Rezoning Transportation Analysis

Petition Number: 2023-002

Date	Description
5-24-23	First Review (IW)
6-13-23	Second Review (DR)

RZ-1

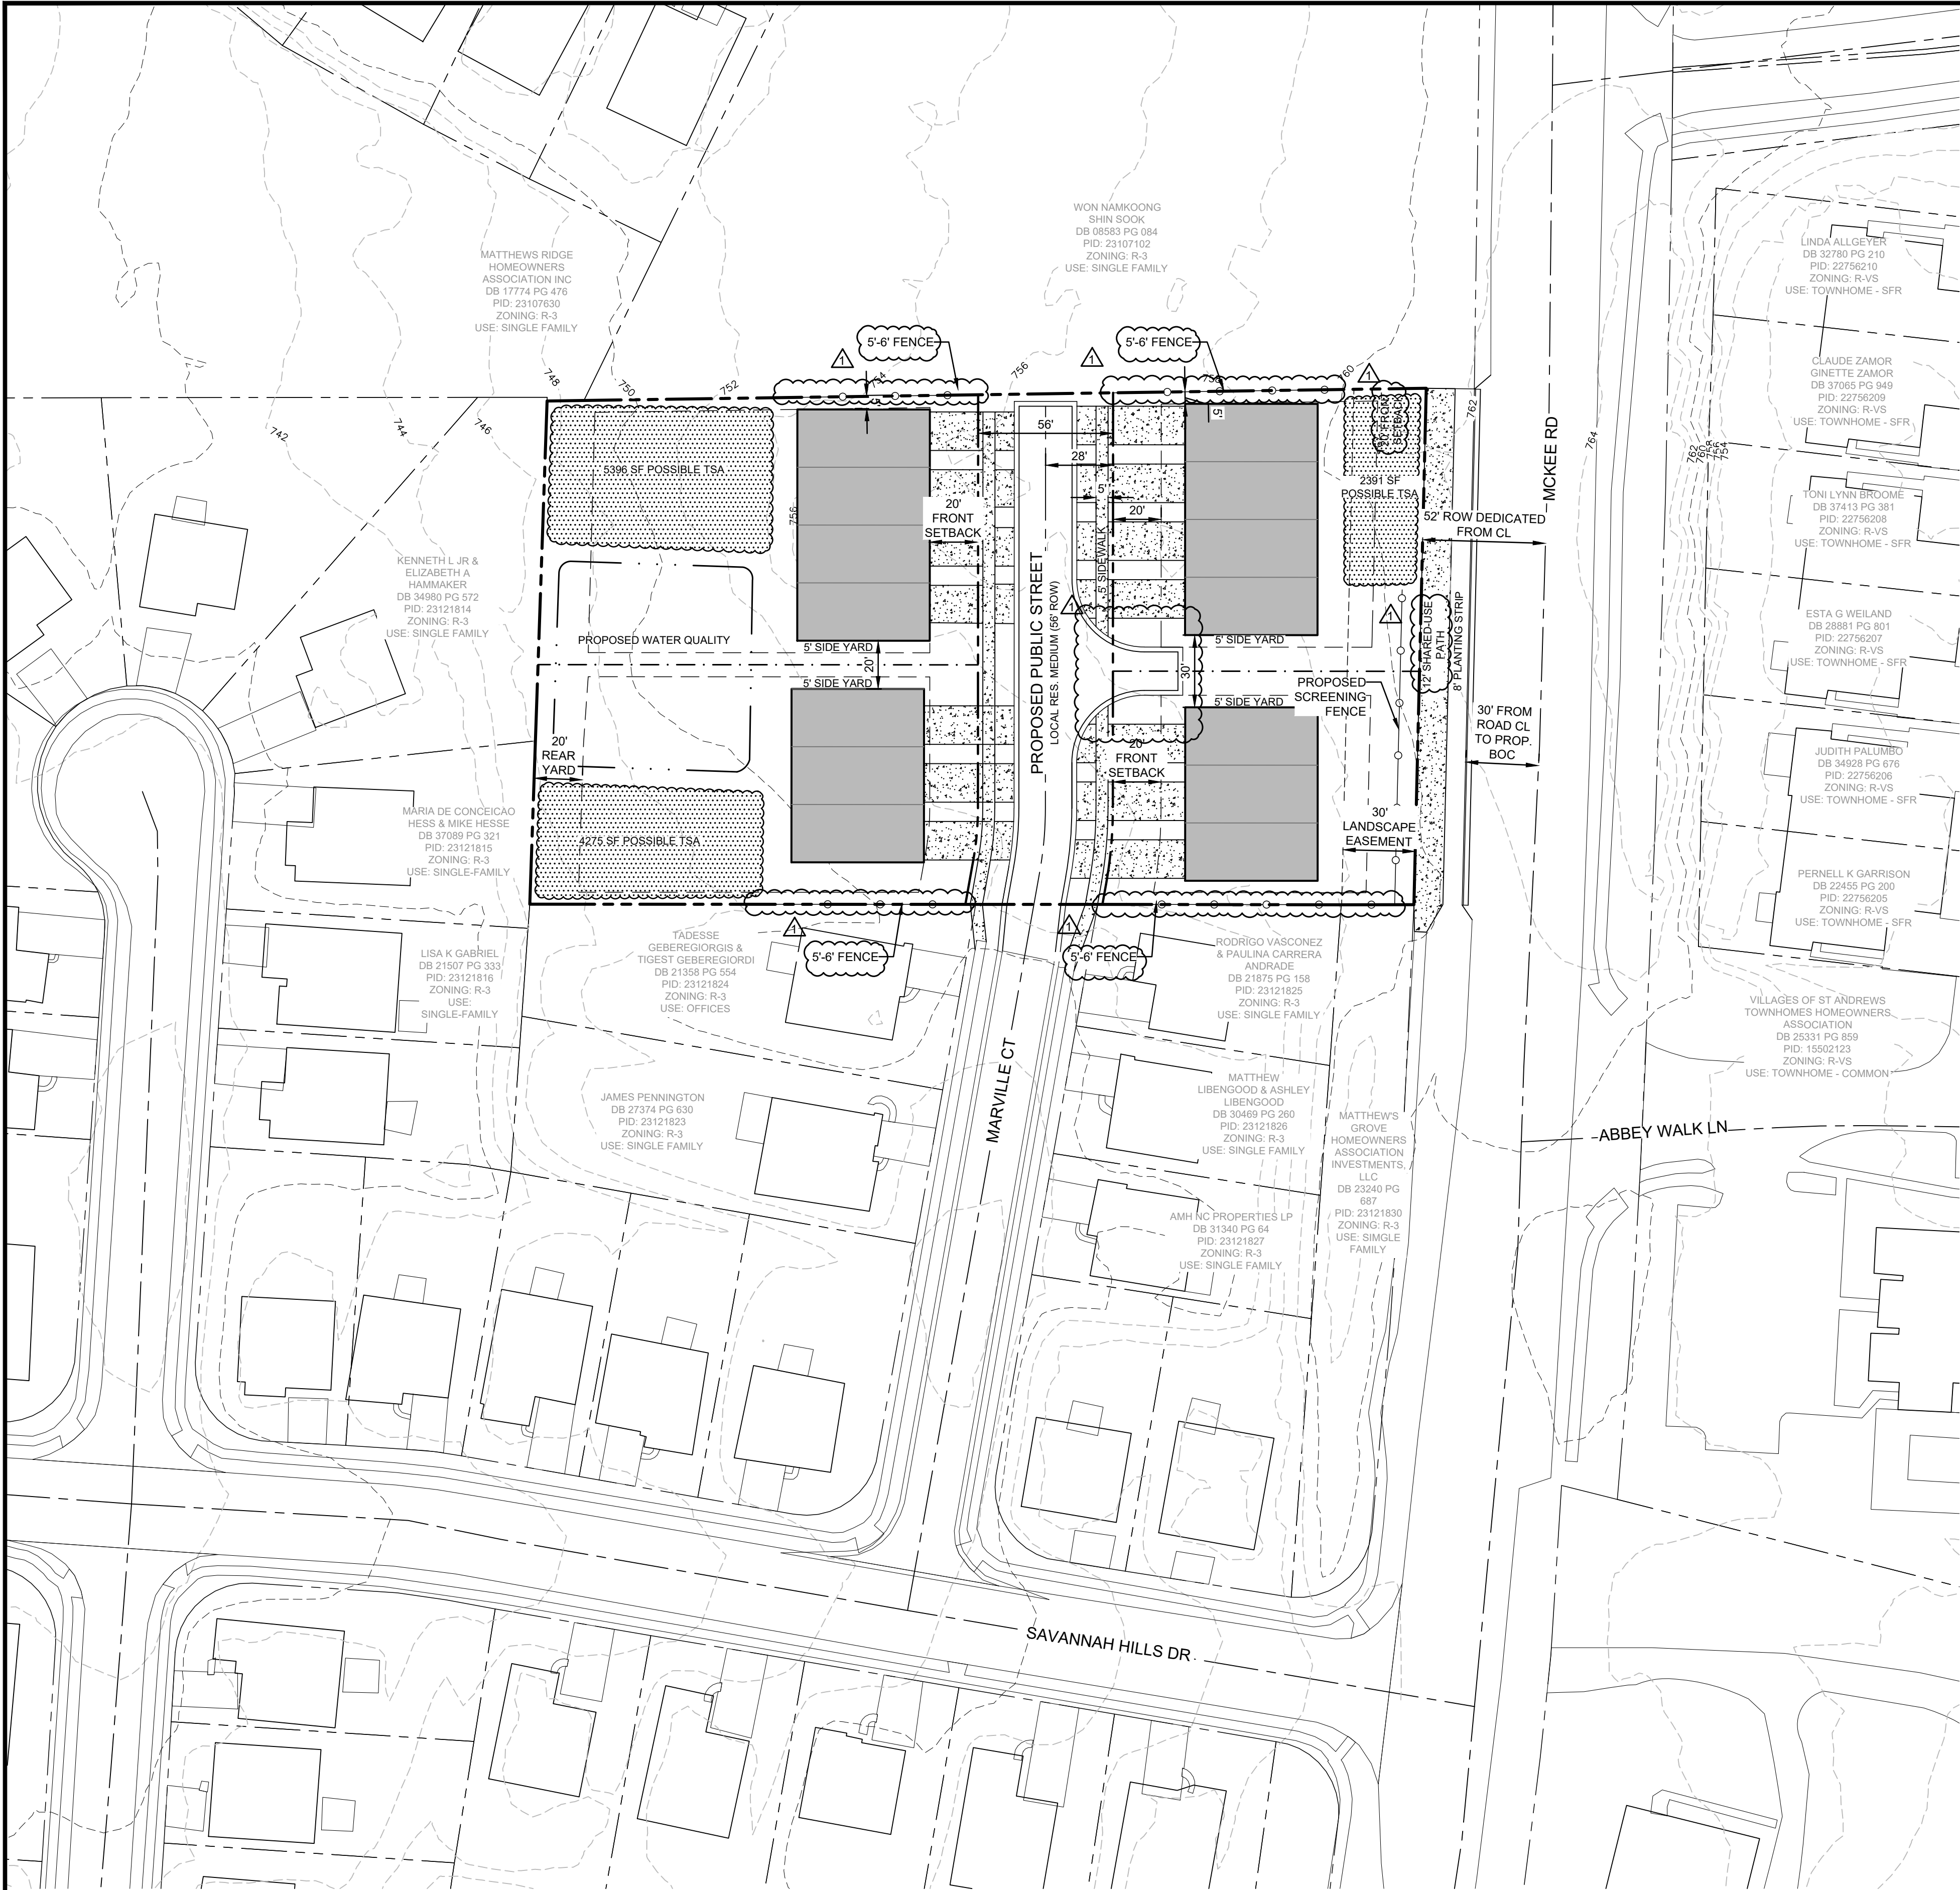
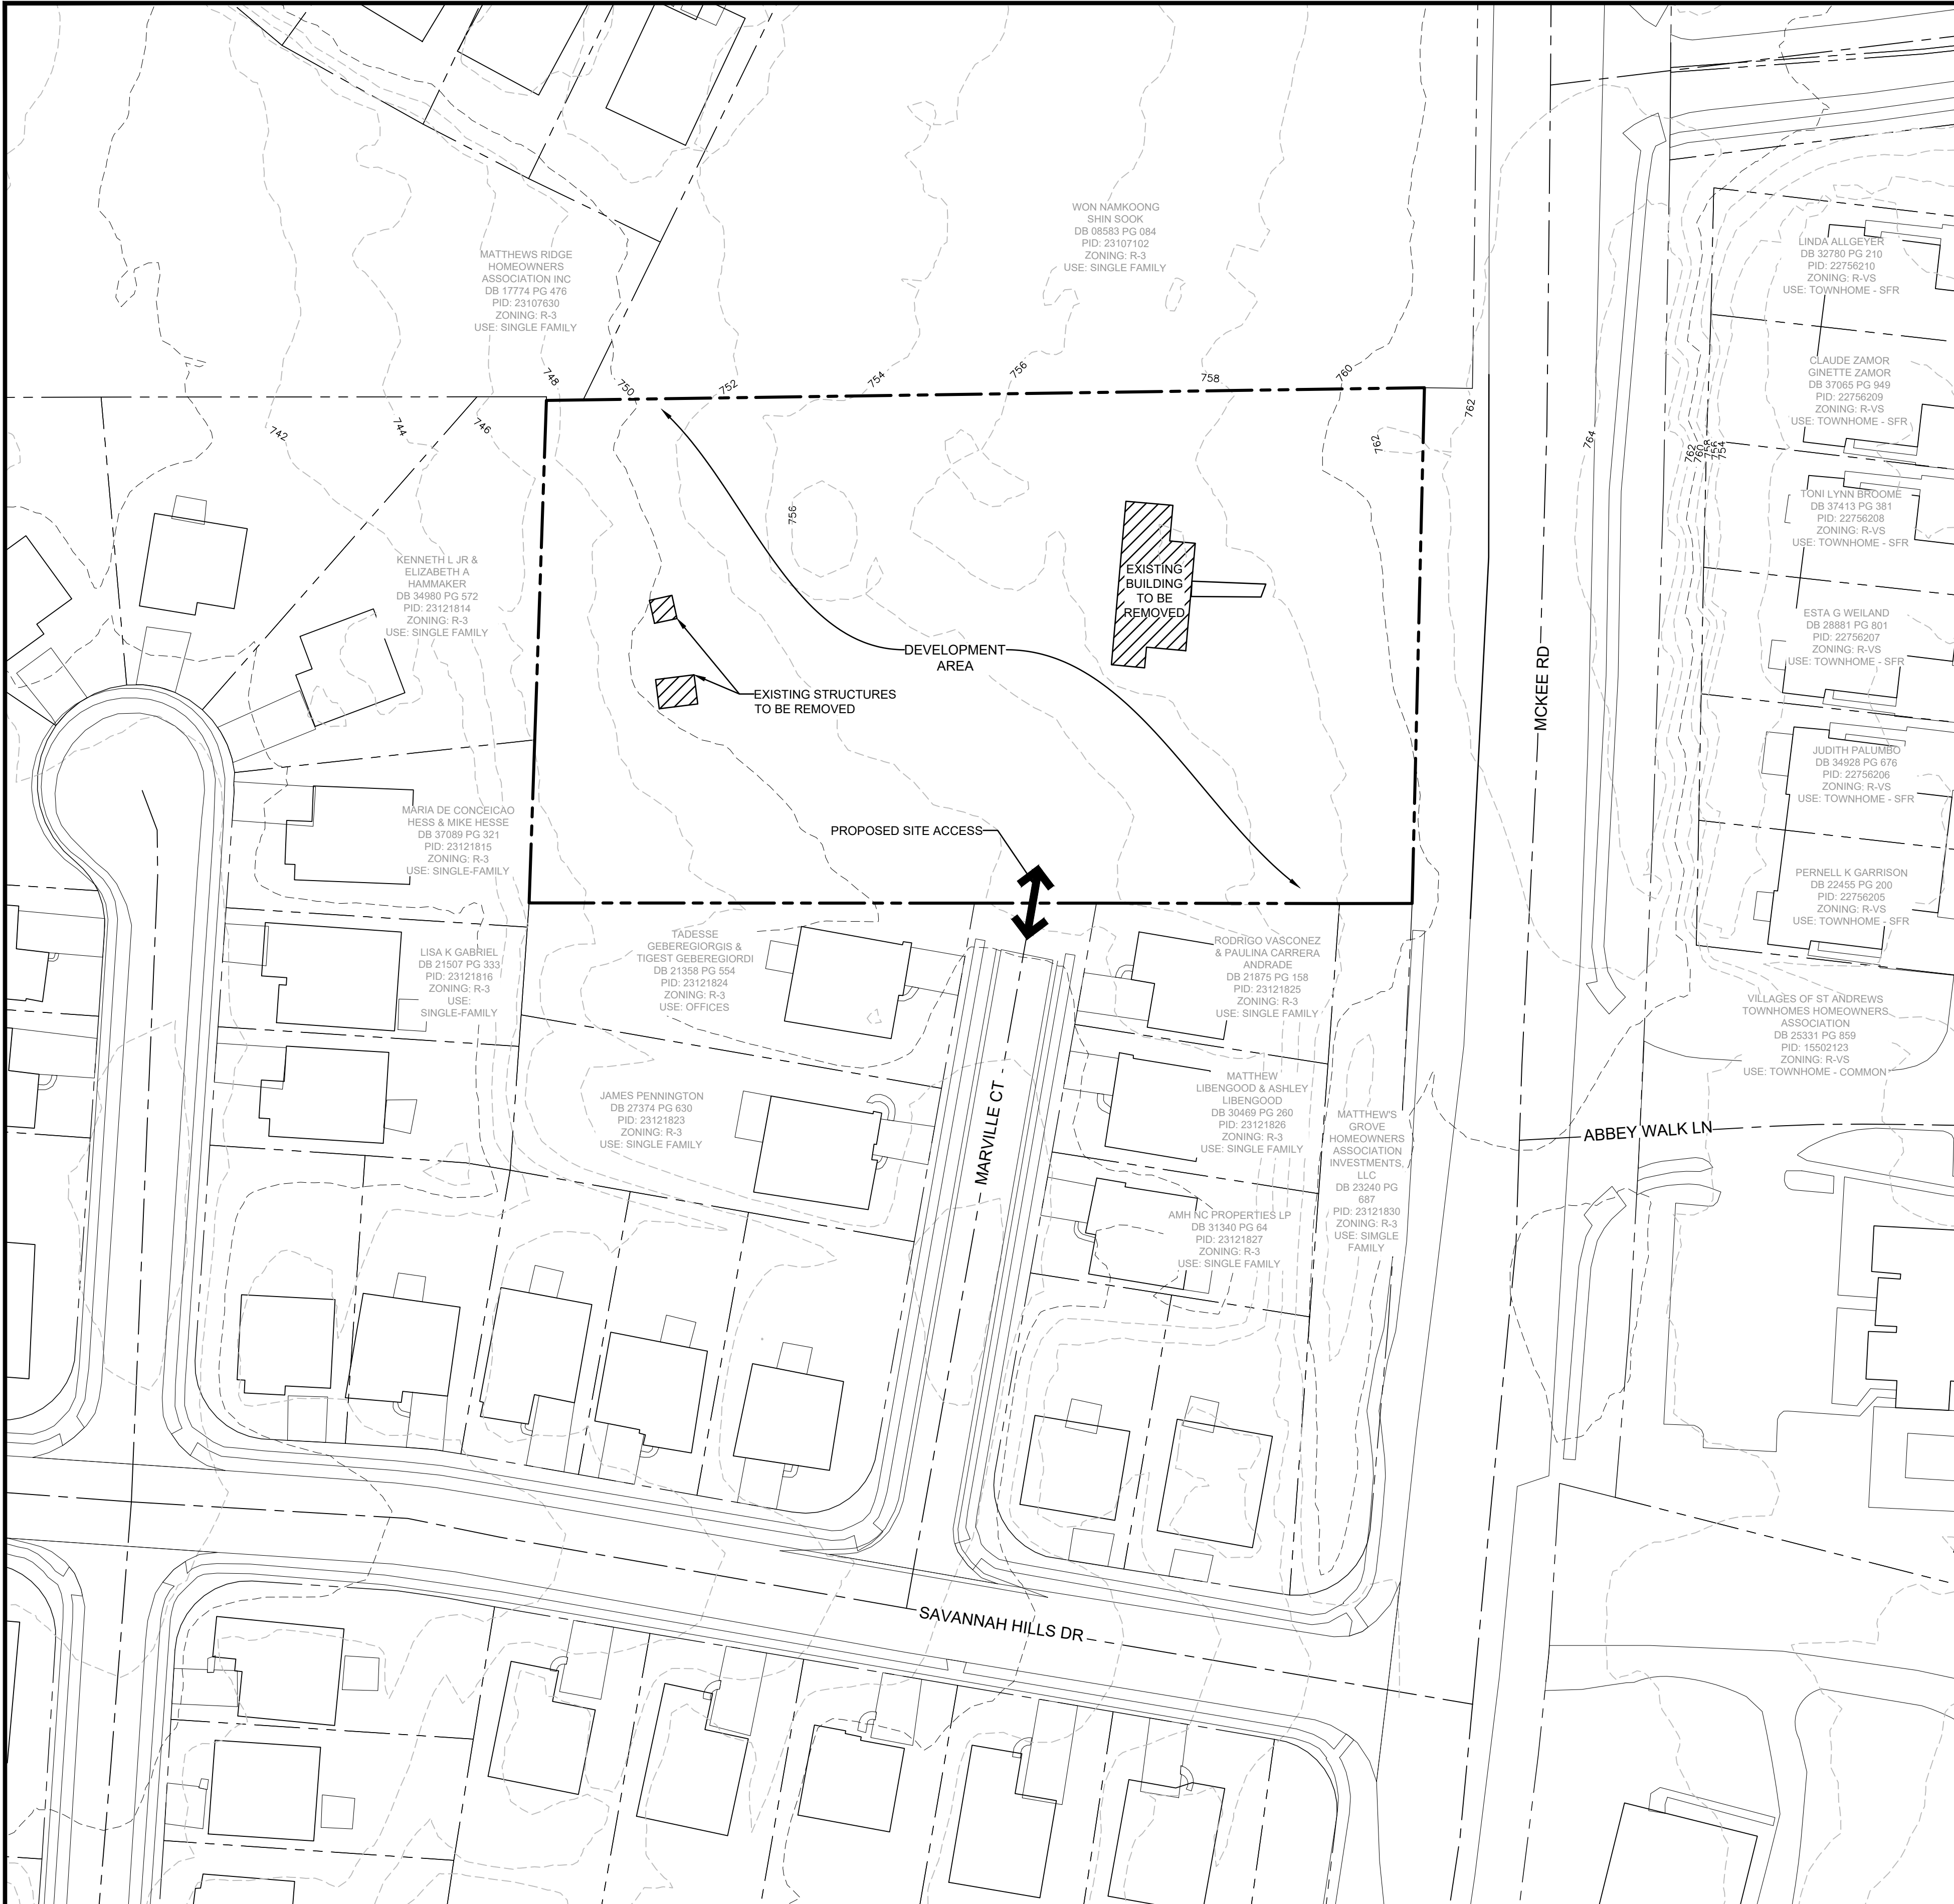
4. ~~Revise site plan and conditional note(s) to commit to better align Marville Ct with road extension by extending the curb and gutter as well.~~
